Lower Thames Crossing

9.181 Final Statement of Common Ground between (1) National Highways and (2) Stuart Mee & Family (Clean version)

**DATE: December 2023
DEADLINE: 9A**

PLAN 6

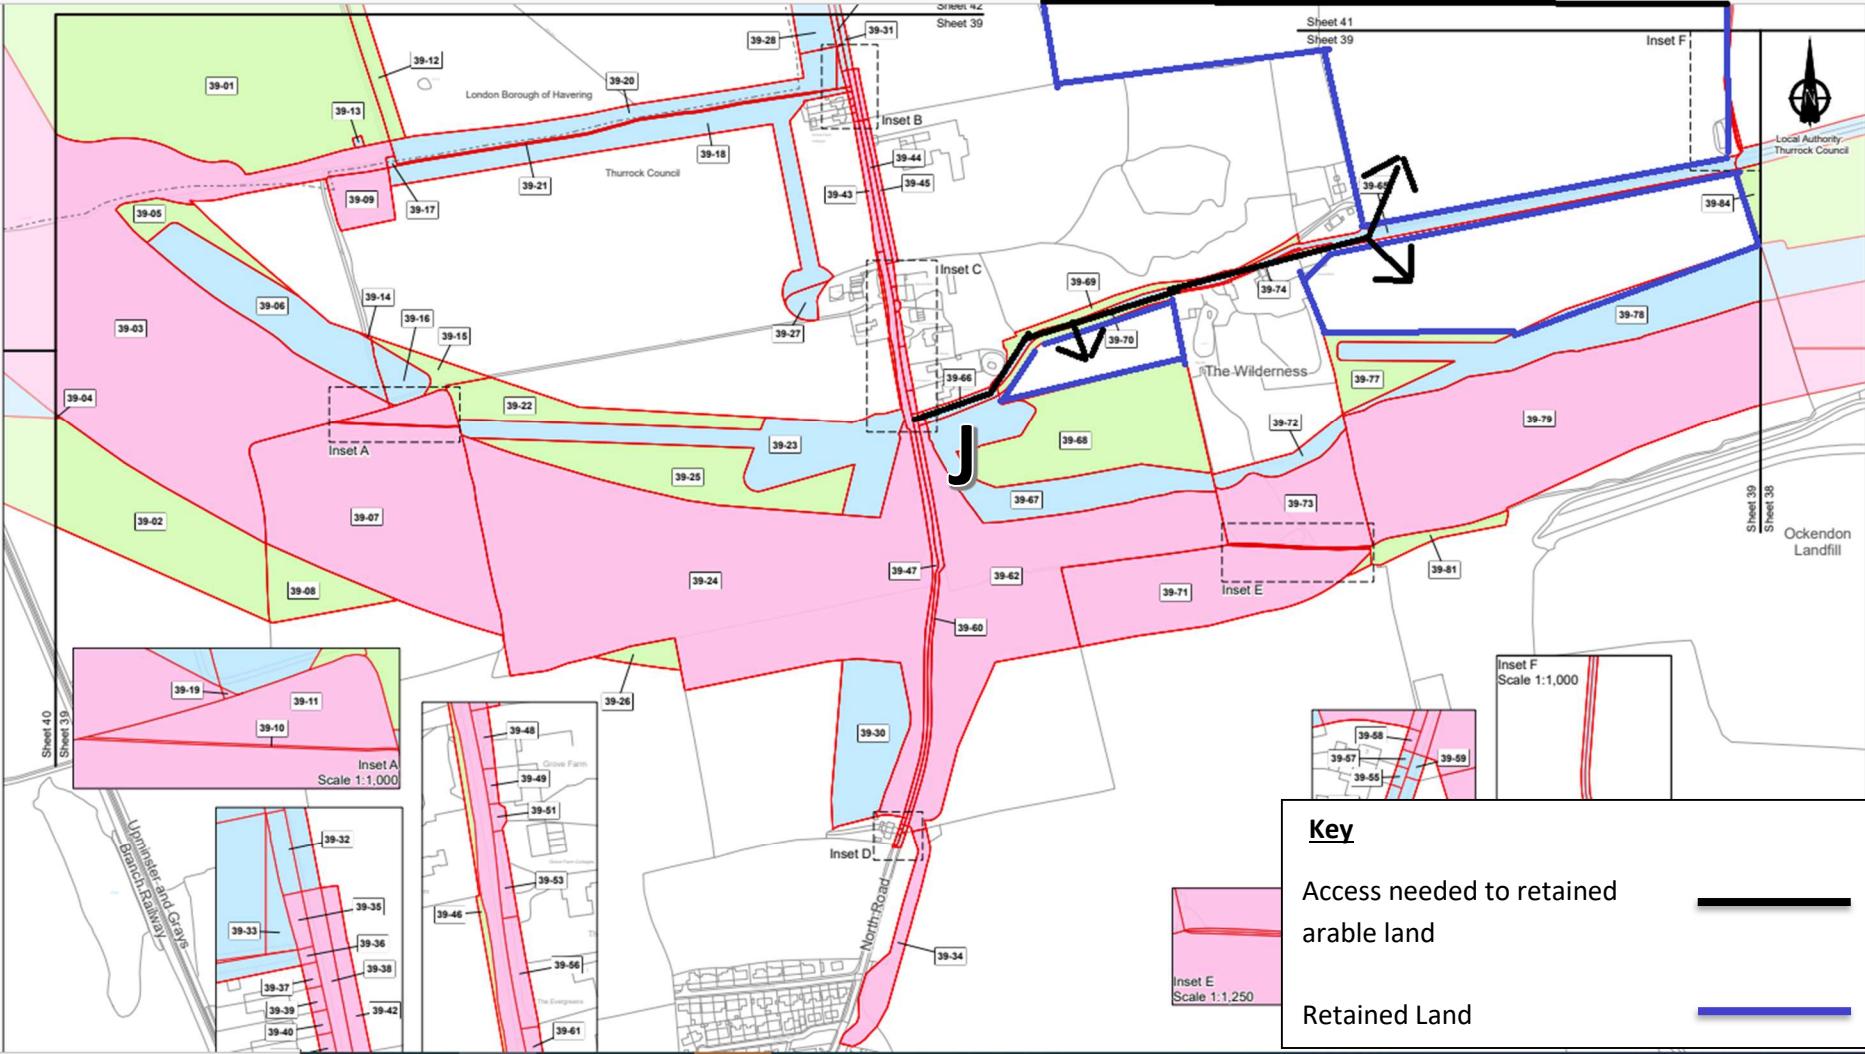
Topic	Item number	Stuart Mee & Family comment (Landowner)	The Applicant's response	Document Reference	Status
Land & Compulsory Acquisition					
Field Accesses	2.1.1	No detail has been provided around the field accesses to the landowners retained land indicated by black arrows into fields edged purple on the Plans 6-8 below in 2.2 Notes are of concern to the Landowner.	SACR-005 in the Stakeholder Actions and Commitments Register (SACR) commits the Contractor to maintain provision for farm access during the construction phase.	Stakeholder Actions and Commitments Register [Document Reference 7.21 (7)]	Matter Agreed* <i>Now secured under SACR-031 and also subject to the completion of the legal side agreement</i>

PLAN 9

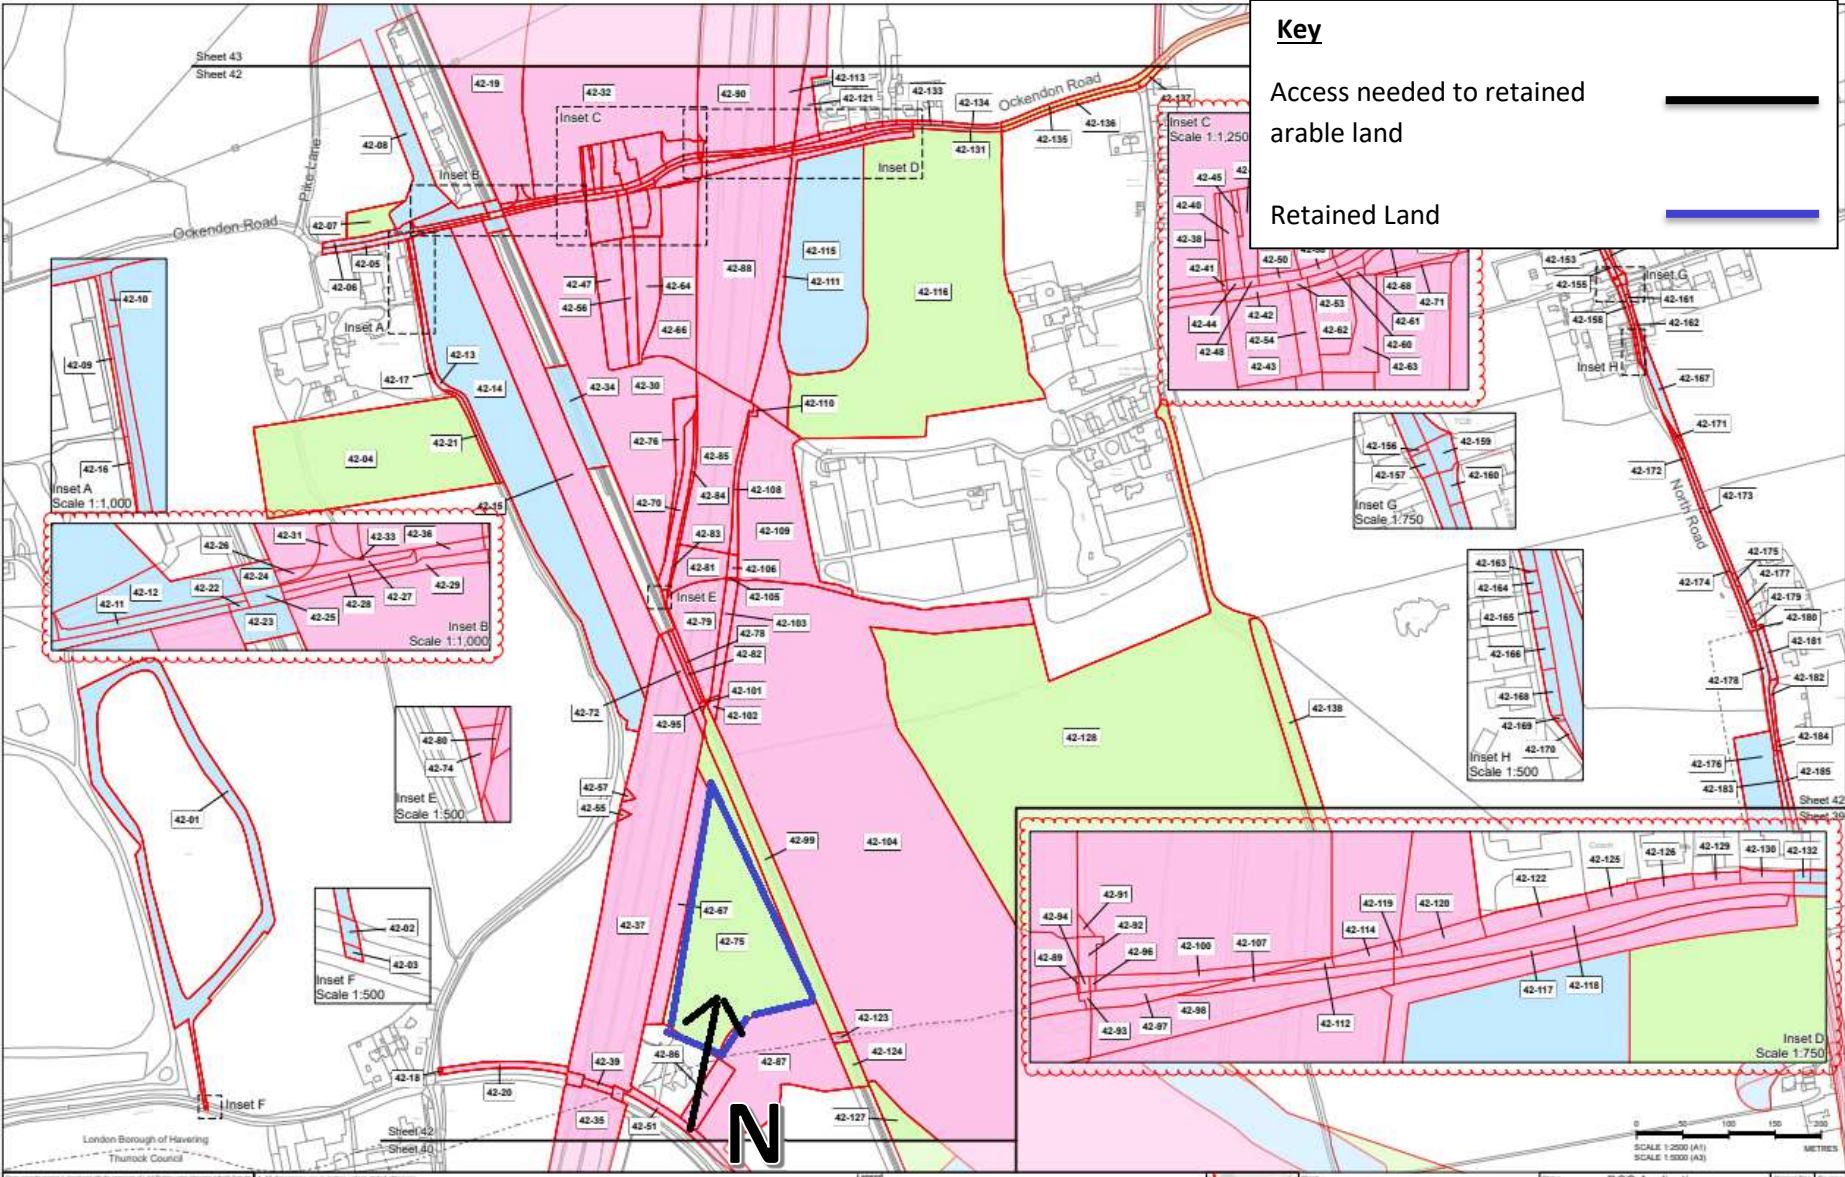
Access off Ockendon Road north across Plot 42-19 & Plot 43-04	2.1.2	No detail has been provided around the field accesses indicated by black arrows into fields and pond edged purple on Plan 9 below in 2.2 Notes are of concern to the Landowner.	The Applicant will transfer the Plots 42-19 and 43-04 to Forestry England and Essex County Council as replacement open space land subject to a permanent right of access from Pike Lane to Hobbs Hole Pond and from	Stakeholder Actions and Commitments Register [Document Reference 7.21 (7)]	Matter Agreed*
